MOOLARBEN COAL COMPLEX
OC4 SOUTH-WEST MODIFICATION
RESPONSE TO SUBMISSIONS

JUNE 2015
Project No. MCM-13-02
Document No. 00682555.docx

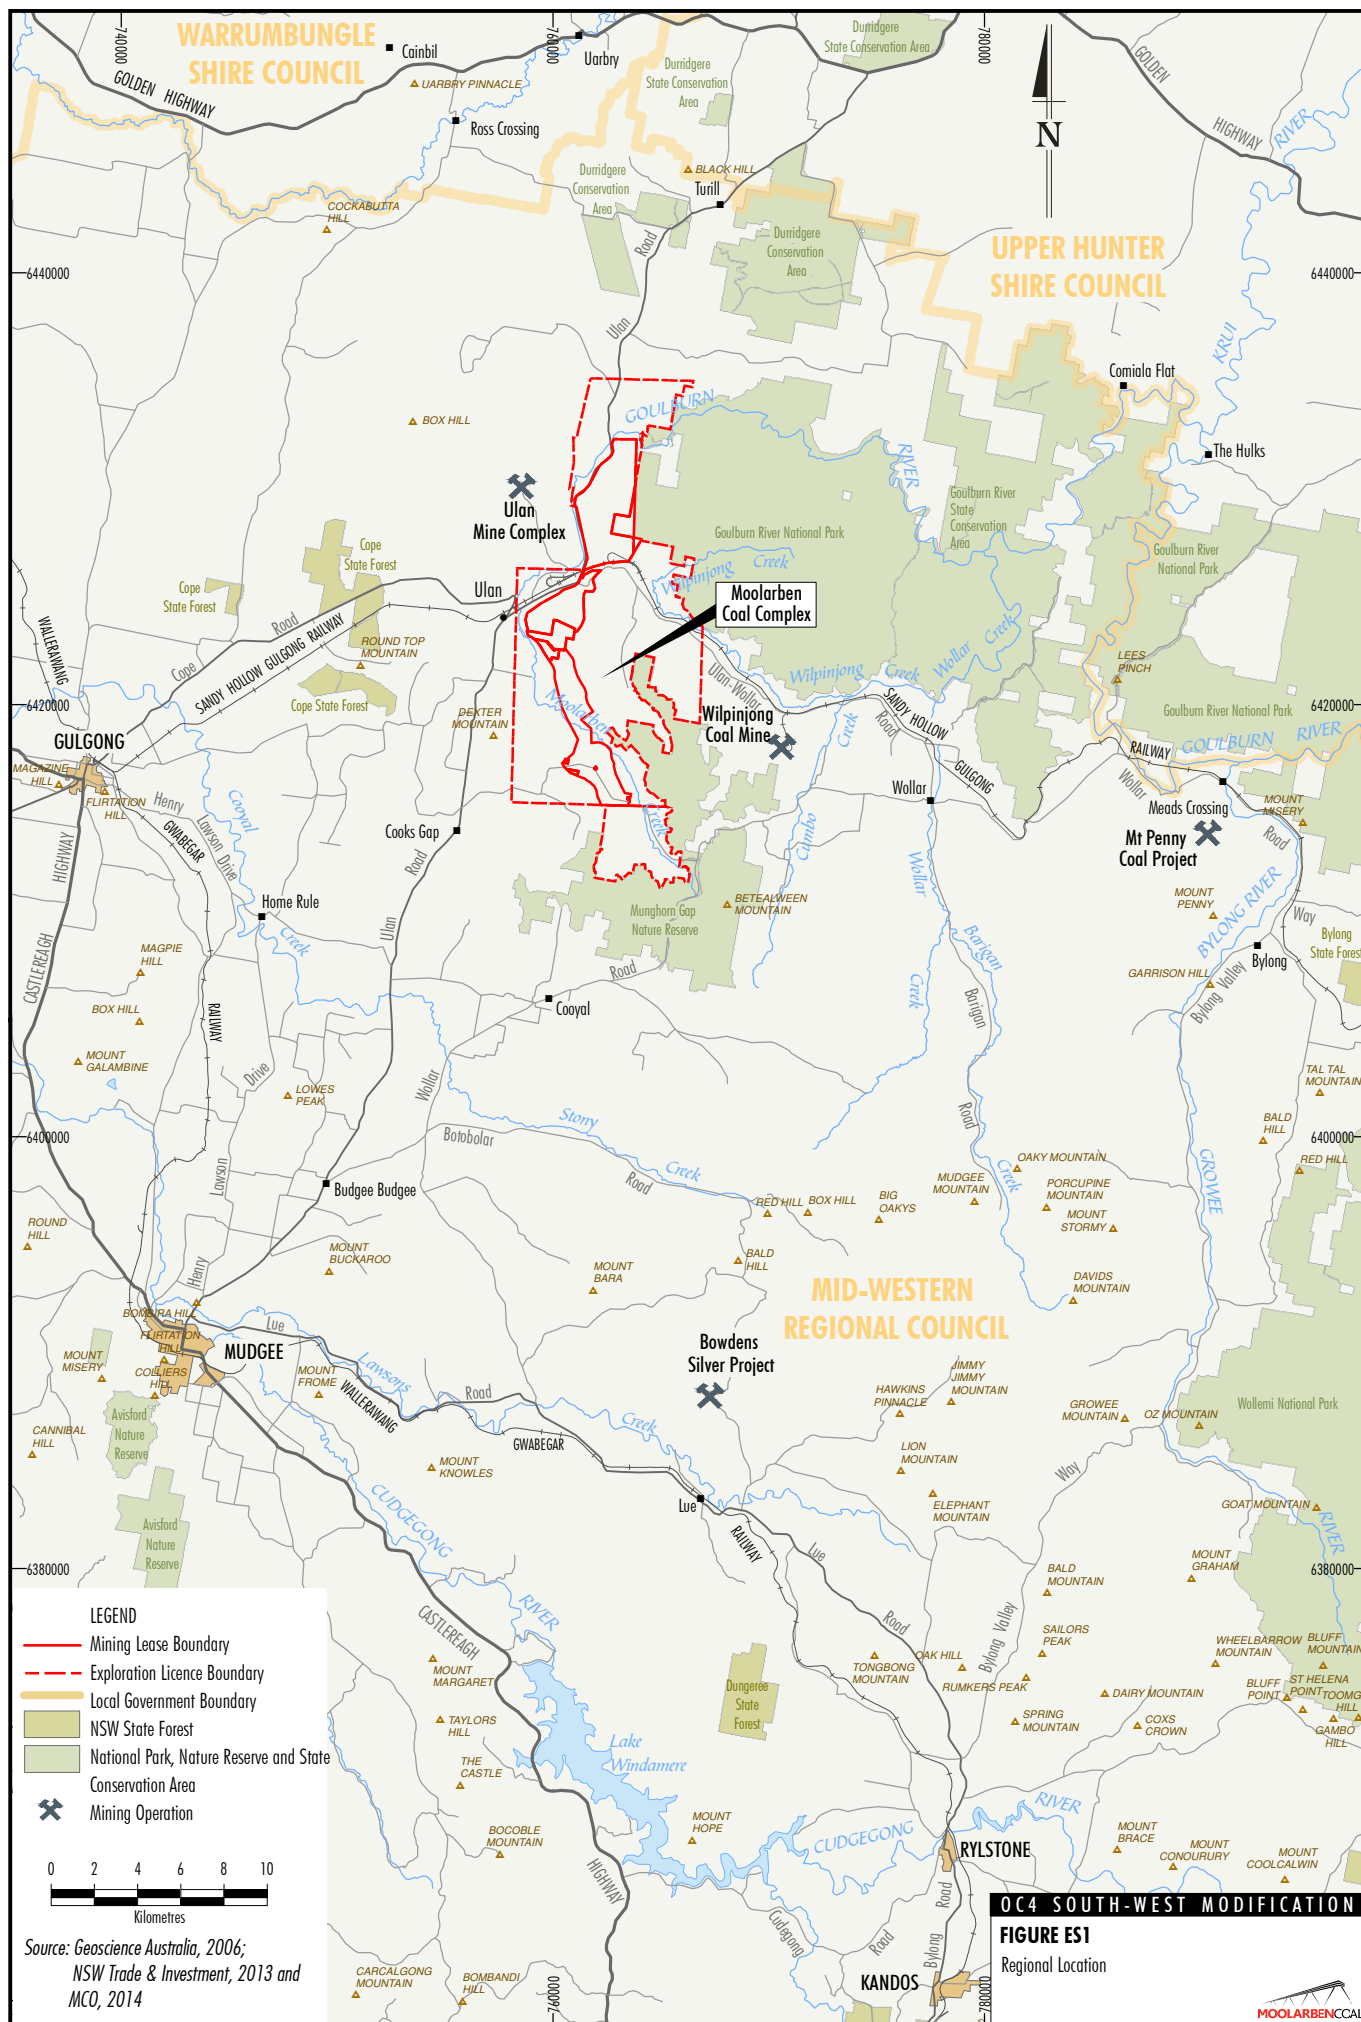
Comment	Response
3. Office of Environment and Heritage (OEH)	
<p>The OEH recommended:</p> <p><i>Recommendation: 1.1 That the location of the approved haul road is confirmed.</i></p>	<p>Figure ES2 and Figure 2 of the Environmental Assessment (Main Text) show the location of both the approved haul road (include road alignment and disturbance extent) and the proposed relocation.</p>
<p>The OEH recommended:</p> <p><i>Recommendation: 1.2 That information regarding the vegetation types, and their condition, is provided to allow direct comparison of impacts of the two routes.</i></p>	<p>Vegetation communities mapped by the Stage 2 EA and PPR within the disturbance footprint of the approved haul road were “Secondary Grassland and Shrublands” and “Western Slopes Dry Sclerophyll Forest”.</p> <p>These communities were subsequently (i.e. in communications from MCO to DP&E post PPR) mapped according to BioBanking Vegetation Type as (Cumberland December 2012):</p> <ul style="list-style-type: none"> • Derived grasslands of the slopes on the Merriwa Plateau (secondary grasslands and shrublands). • White Box – Narrow-leaved Ironbark shrubby open forest on hills of the central Hunter Valley, Sydney Basin (Western Slopes Dry Sclerophyll Forest). <p>The Stage 2 PPR originally described the secondary grassland as poor quality. However, during the assessment of the application these areas were re-classified into a native Biobanking Vegetation Type and offset accordingly.</p> <p>The approved haul road includes approximately 17.4 ha of Derived grasslands of the slopes on the Merriwa Plateau (as mapped in the Stage 2 EA/PPR) and 1.1 ha of White Box – Narrow-leaved Ironbark shrubby open forest on hills of the central Hunter Valley (as mapped in the EA/PPR). Total of 18.5 ha.</p> <p>In comparison, the proposed haul road contains approximately 1.8 ha of Grey Gum - Narrow-leaved Stringybark - Ironbark Woodland on ridges of the upper Hunter Valley and 3.3 ha of White Box – Narrow-leaved Ironbark Shrubby Open Forest on hills of the central Hunter Valley. Total of 5.1 ha.</p> <p>Of note, since original recording and community allocation in 2007, the secondary grassland (as mapped in the EA and re-produced in the PPR) has undergone substantial natural regeneration (e.g. due to the removal of stock). EcoLogical Australia consider that if this area were to be re-mapped to contemporary classification standards that the areas of natural regeneration would be mapped as forest or woodland communities as opposed to grassland.</p> <p>As described in the OC4 Modification, the Moolarben Coal Project Stage 2 project includes the clearing of approximately 1,534 ha of native vegetation, including 902 ha of remnant vegetation and 632 ha of grassland (including 123 ha of the <i>Box-Gum Woodland and Derived Native Grassland</i> threatened ecological community).</p> <p>The vegetation loss within the Stage 2 approval area has resulted in the provision of ecological offsets totalling 4,822 ha of native vegetation, including 3,689 ha of remnant vegetation, 1,134 ha of grassland (including 1,154 ha of <i>Box-Gum Woodland and Derived Native Grassland</i>).</p> <p>The proposed haul road disturbance area represents a smaller area to be cleared than the approved haul road, creating surplus offset areas. The approved haul road would impact 18.5 ha which is approximately 13.4 ha more vegetation than the proposed OC4 haul road realignment. The current Biodiversity Offset Strategy developed for Stage 2 therefore adequately covers the proposed impacts from the proposed haul road realignment, with surplus area.</p>
